SITE DEVELOPMENT PLANS

LOT 3, APPALOOSA HIGHWAY 24 SUBDIVISION

Markup Summary

SHEET NO:
C-01

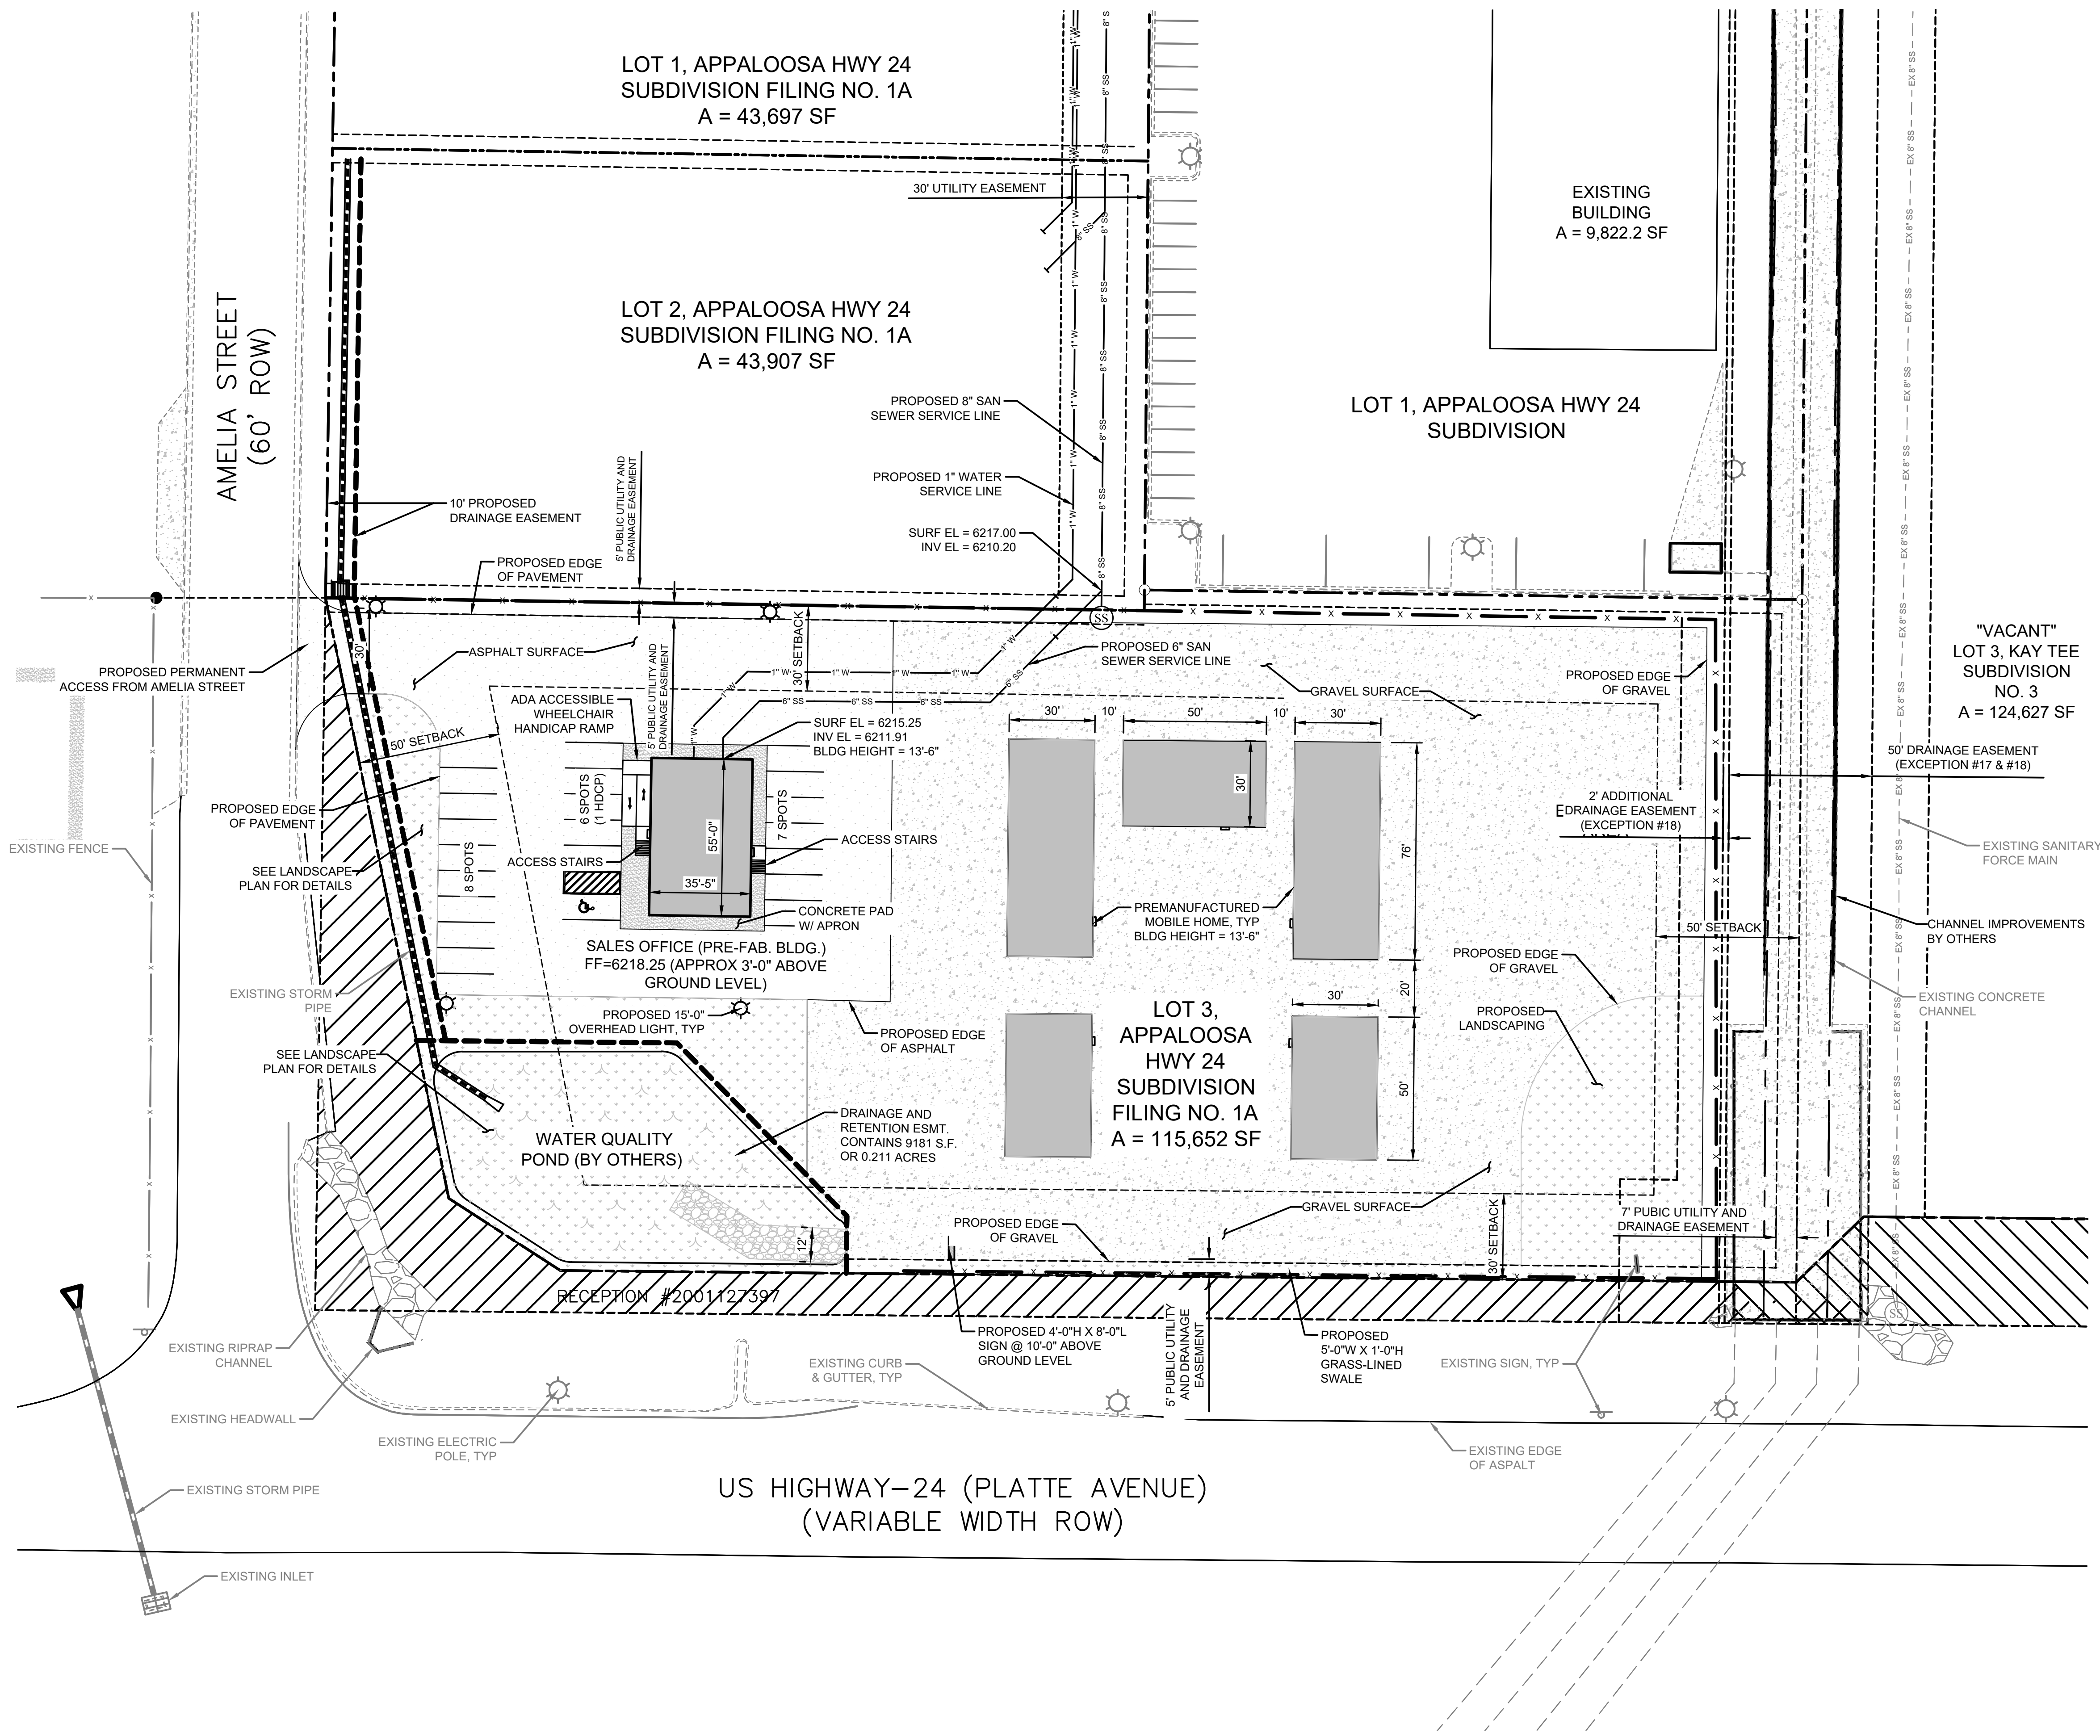
Trees cannot be installed directly over drainage facilities

Show the maintenance access to the outlet structure.

Roadway landscaping required. 25 foot buffer + 1 tree per 20 feet of roadway.

Internal landscaping required. 5% of total square footage. 75% of that must be live ground cover.

Roadway landscaping required - non arterial. 10 foot buffer plus 1 tree per 30 feet.

Parking lot needs to be screened - 3 ft tall berms or landscaping.
